July 16, 2015

**RE: Unser & Vista Oriente Shell Building, Lot 1-B-3, Ladera Industrial Center,
Unser Boulevard
Grading and Drainage Plan
Engineer's Stamp Date 5-19-2015 (File: H10-D006A5)**

**RE: Unser & Vista Oriente Shell Building, Lot 1-B-3, Ladera Industrial Center,
Unser Boulevard
Grading and Drainage Plan
Engineer's Stamp Date 5-19-2015 (File: H10-D006A5)**

SHEET NO:
CG-101

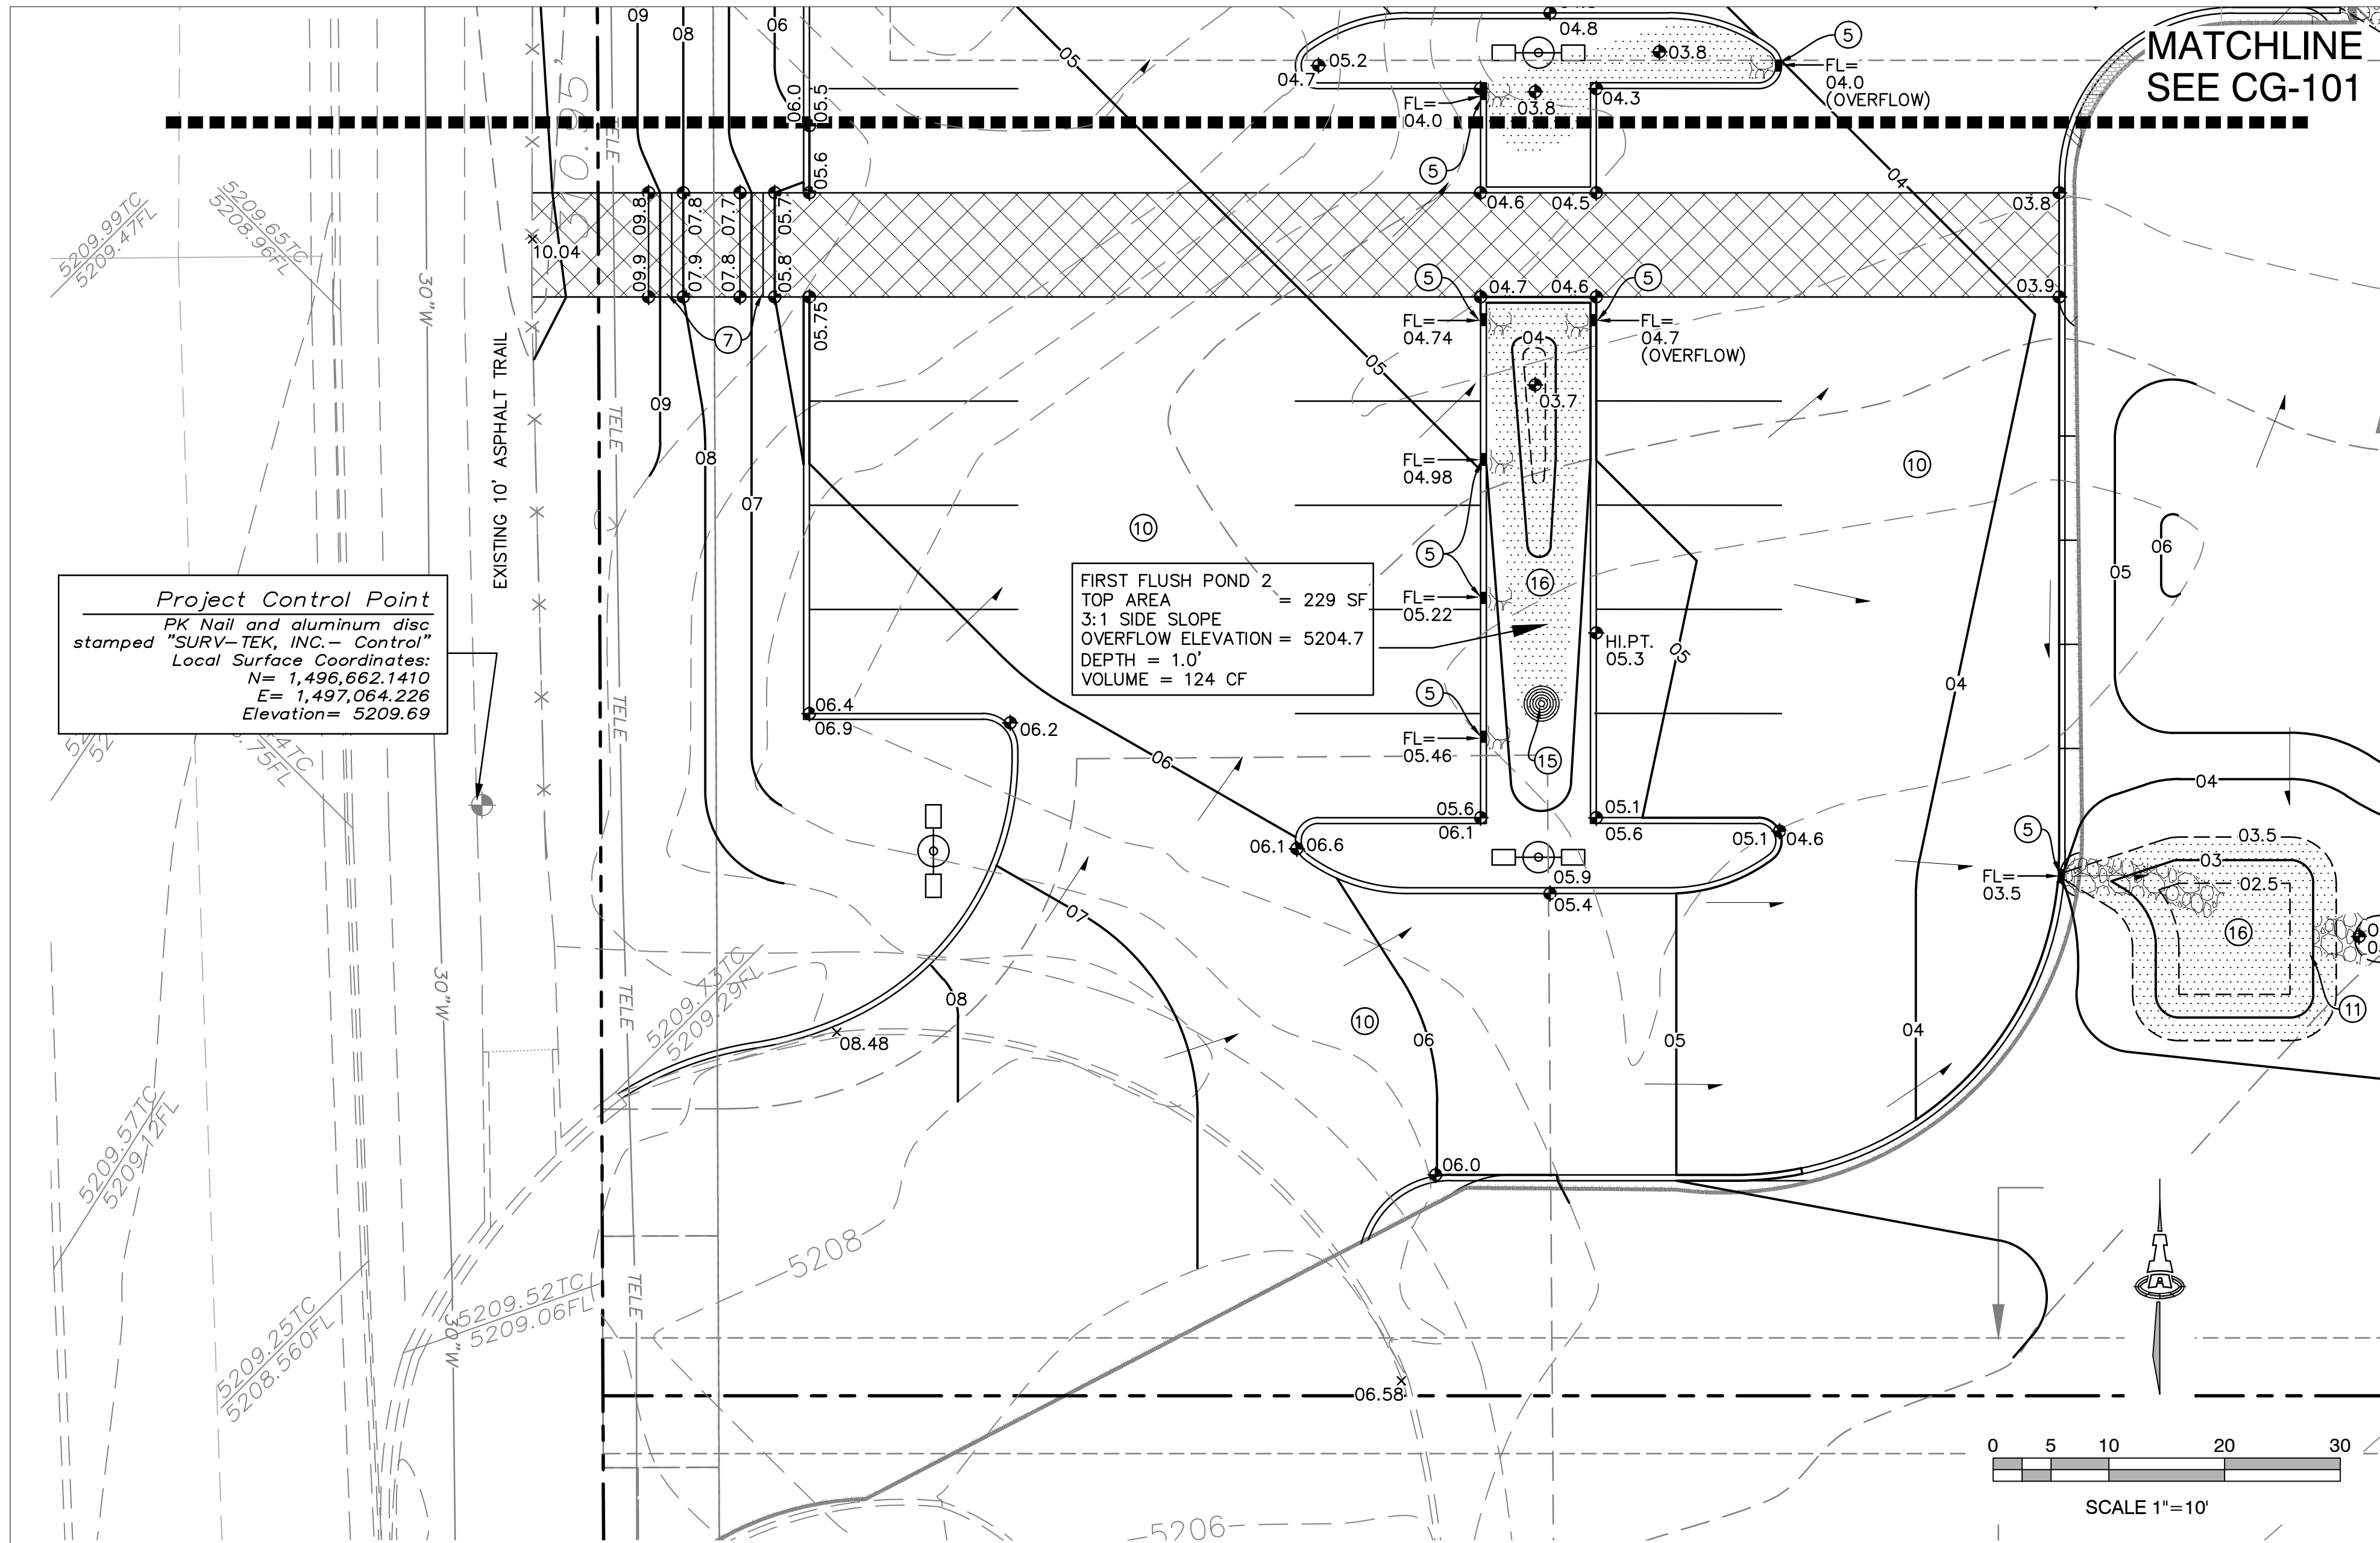
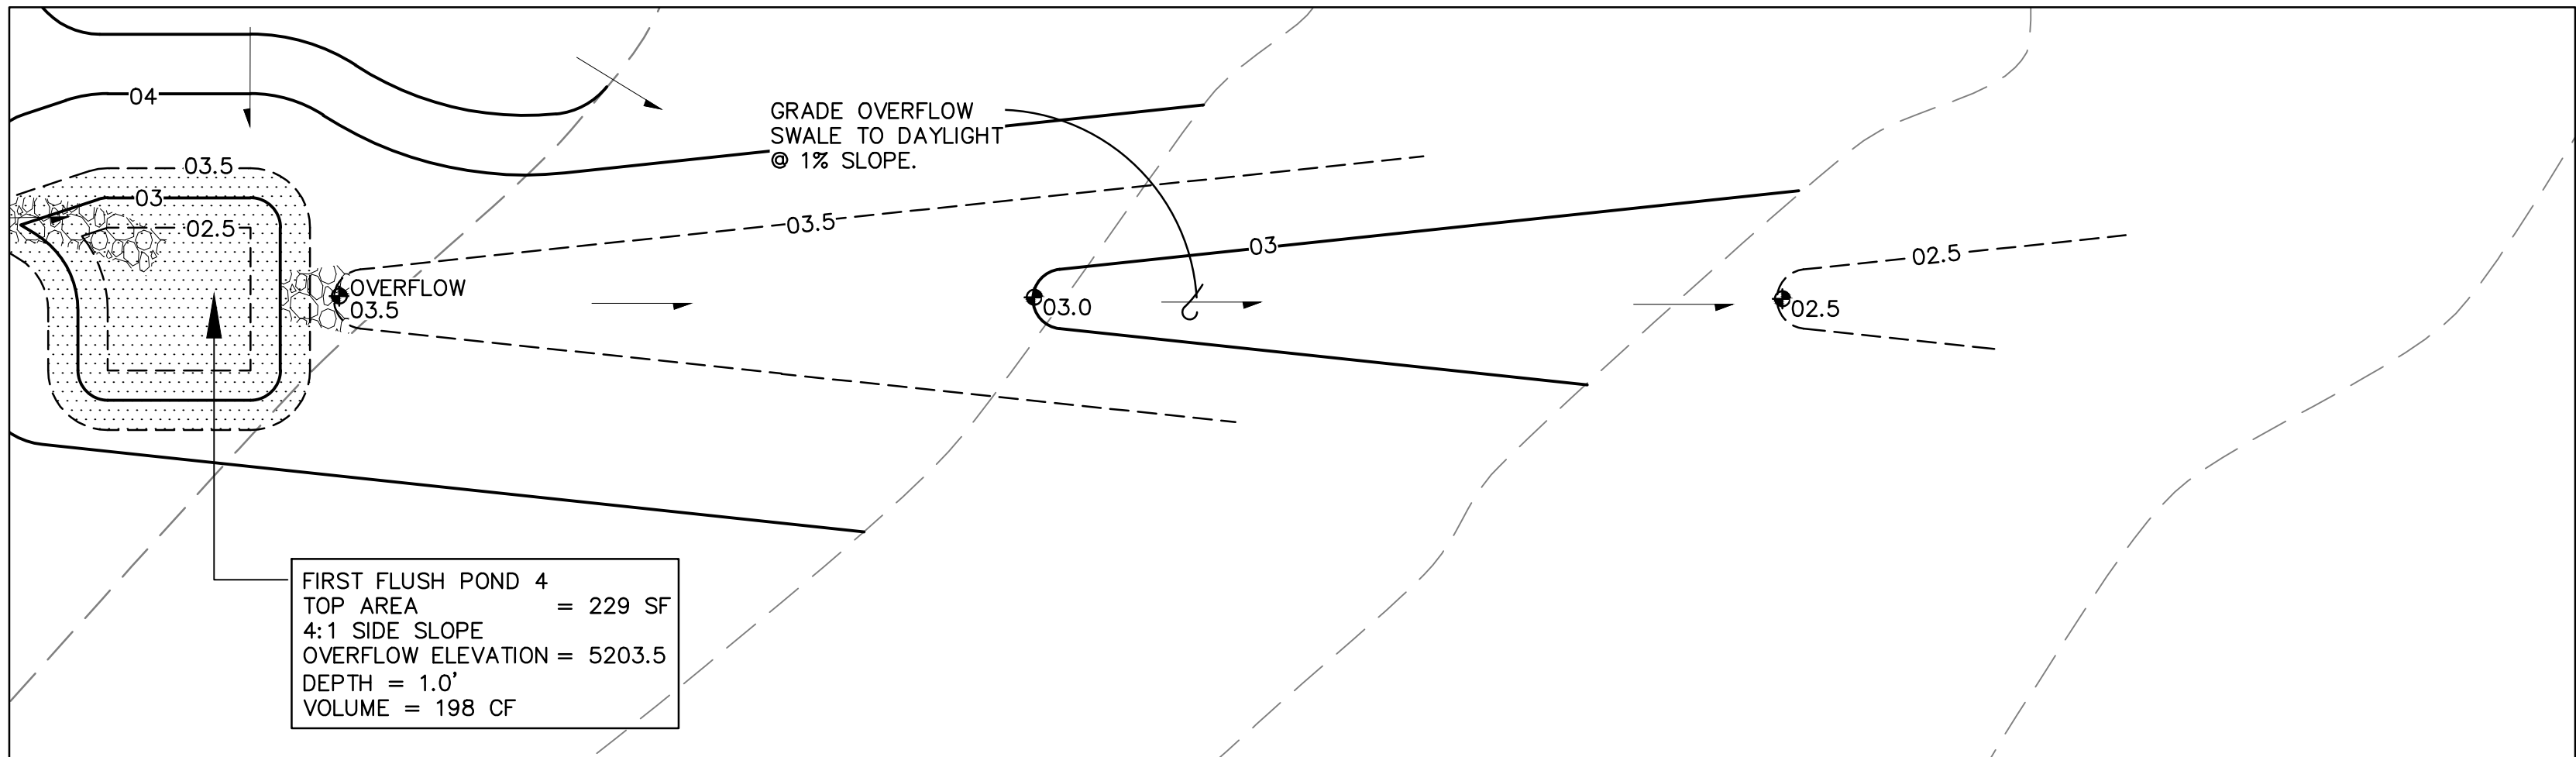
- 1) Provide excerpts from the Ladera Industrial Center Site Development Plan showing that the site adjacent to the east is accepting on-site flow. Since the storm flow is increased from existing conditions, a cross-lot access agreement may be needed unless one is already in place to accept the proposed 100-year flow.
- 2) A couple of the new spot elevations were cut off on the right side of the plan view on Sheet CG-102.
- 3) For Basin 3 on Sheet CG-501, the labeling of the basin area on the plan view needs to match the basin area in the calculations. Also, label lot line for Lot 1-B-3.
- 4) Show roof drains.

- b. Regarding cross-lot drainage: per our Drainage Concept on Sheet CG-101: EXISTING MUTUAL CROSS LOT DRAINAGE EASEMENT FOR THE BENEFIT OF LOTS 1-B-1 THRU 1-B-4 GRANTED BY PLAT FILED JANUARY 26, 2012. SAID EASEMENT SHALL RUN OVER, UNDER AND ACROSS THE COMMON AREAS (MEANING THOSE AREAS OF LOT NOT OCCUPIED BY A BUILDING FROM TIME TO TIME AND AT ANY APPLICABLE TIME). MAINTENANCE OF SAID EASEMENT SHALL BE THE RESPONSIBILITY OF THE RESPECTIVE LOT OWNERS AS TO THE PORTION CONTAINED WITHIN THEIR RESPECTIVE LOT.

2. The referenced spot elevations which are cut off on the right side of the plan view are continued on the insert at the bottom of sheet CG-102. Per keyed note #11:
FIRST FLUSH POND (TEMPORARY). SEE INSERT THIS SHEET FOR CONTINUATION.
3. Basin area 3:
- a. On sheet CG-501 is labeled 14,308 SF with 10,162 SF land treatment 'D'. This does match the calculations shown.
 - b. Regarding the comment "label lot line for 1-B-3". Sheet CG-101 provides the metes and bounds for the portion of the lot in the vicinity of the construction. Sheet CG-501 (top image) shows the lot outline and flags it as Lot 1-B-3. If you need additional labeling information, let me know.
4. The roof drain is shown on CG-101 and is identified as keyed note #3.
BUILDING ROOF DISCHARGE LOCATION. EXTEND DRAIN PIPE THROUGH WALK TO RELEASE DIRECTLY TO FIRST FLUSH POND #1.
SEE ARCHITECTURAL FOR ADDITIONAL INFORMATION.
